PLANNING AMENDMENT

Application No. H12/0480/06/A1

ST MARTIN VESTMENTS, LUTTON BANK, LUTTON

CHANGE OF USE FROM
VESTMENT MANUFACTURE TO
DWELLING

SD06-019/1

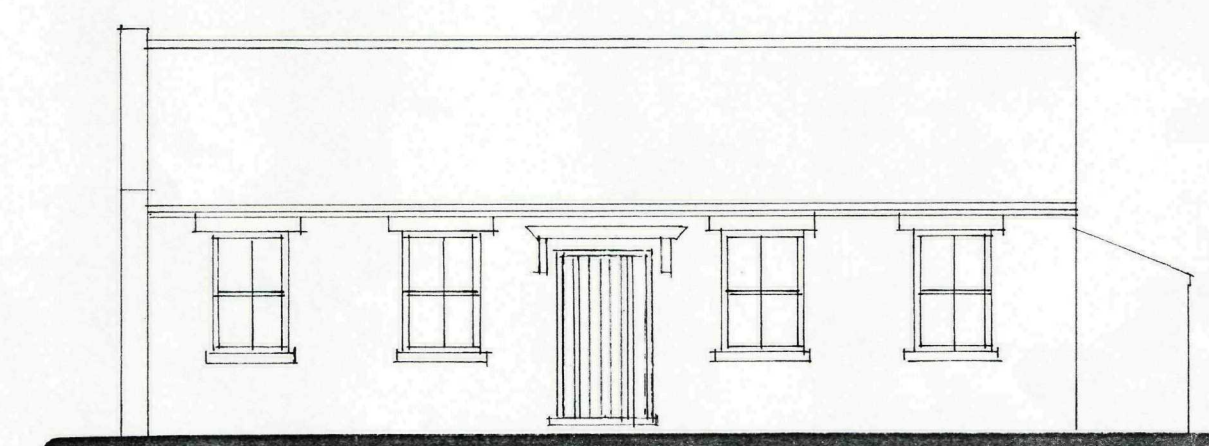
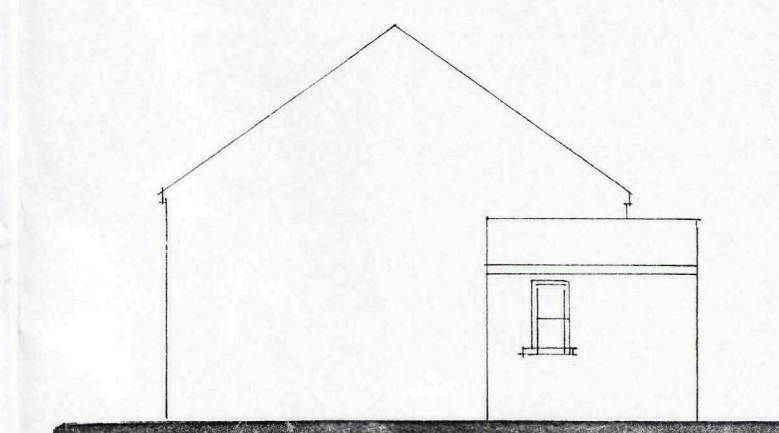
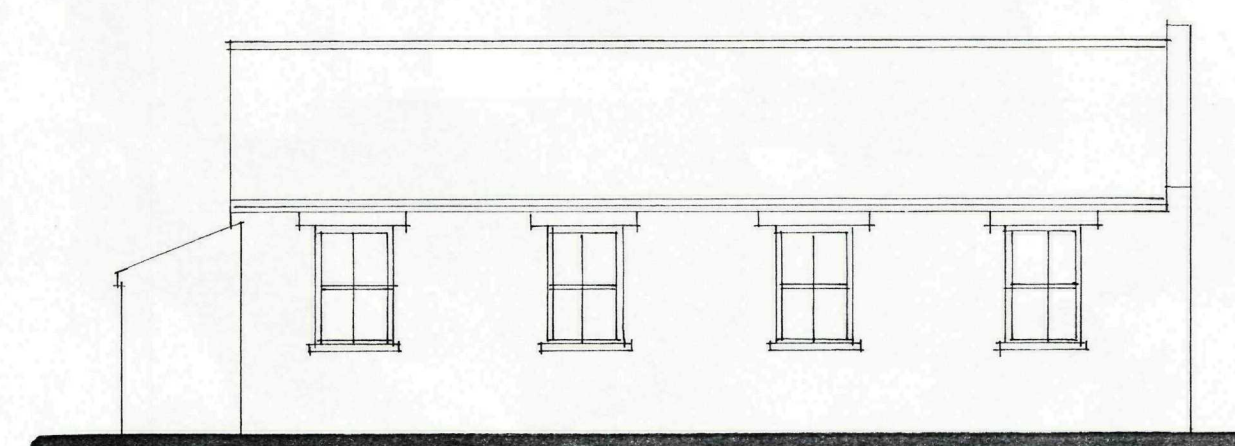
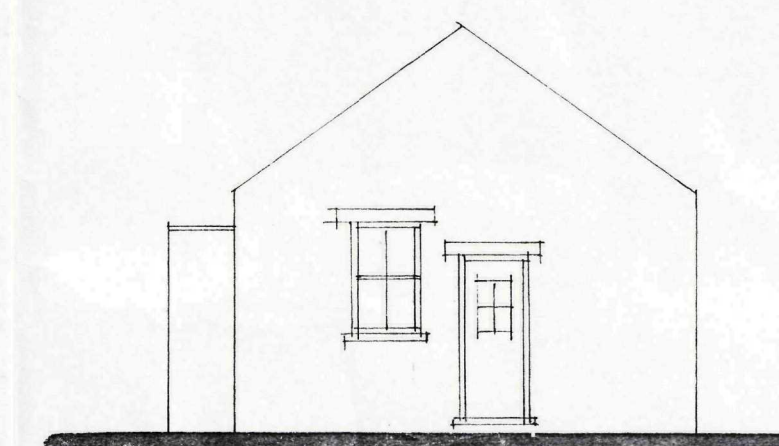
REVISED FENESTRATION
